## Longfield Solar Farm

### Braintree District Council (BDC)

Unique Reference: LOSF – 0003

### ExQ3 - Responses to Written Questions

FIGURE NUMBER  
Figure 2-5

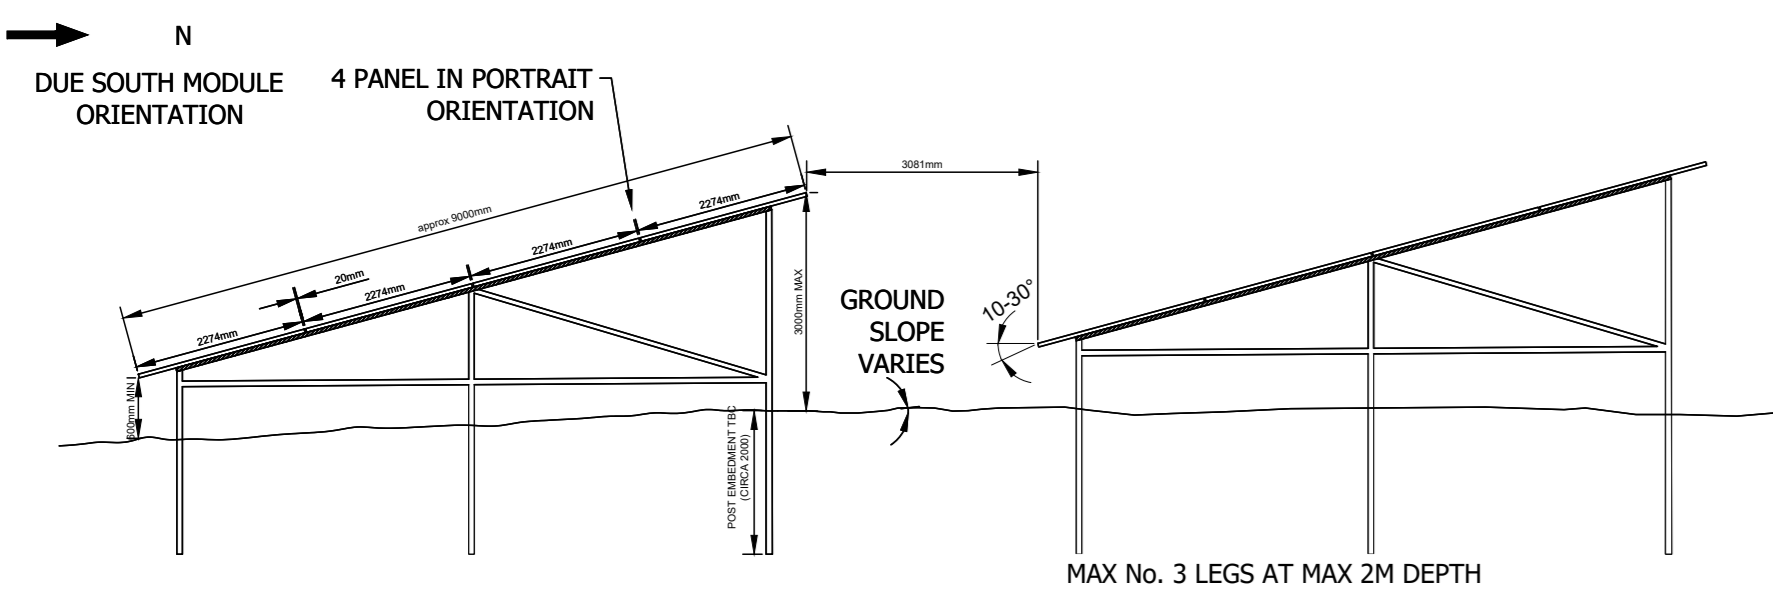
ExQ	Respondent	Question	Braintree District Council Response
2. Biodiversity, Ecology and the Natural Environment; Habitats Regulations Assessment			
3.2.3	Braintree District Council	<p>The ExA notes that ES Figure 2-5 (Illustrative Concept Design/Operational Layout Overview) [REP3- 041] and ES Figure 10-15 (Vegetation Removal Plan) [REP5-006] have been updated to reflect the micro-siting of the track to avoid the RPA of the veteran tree (T9). The ExA also notes that the oCEMP has been updated [REP4-014] to incorporate additional mitigation. Please indicate whether or not the Council considers any further mitigation is required in relation to veteran trees.</p>	<p>BDC do not consider that any further mitigation is required in relation to veteran trees.</p>
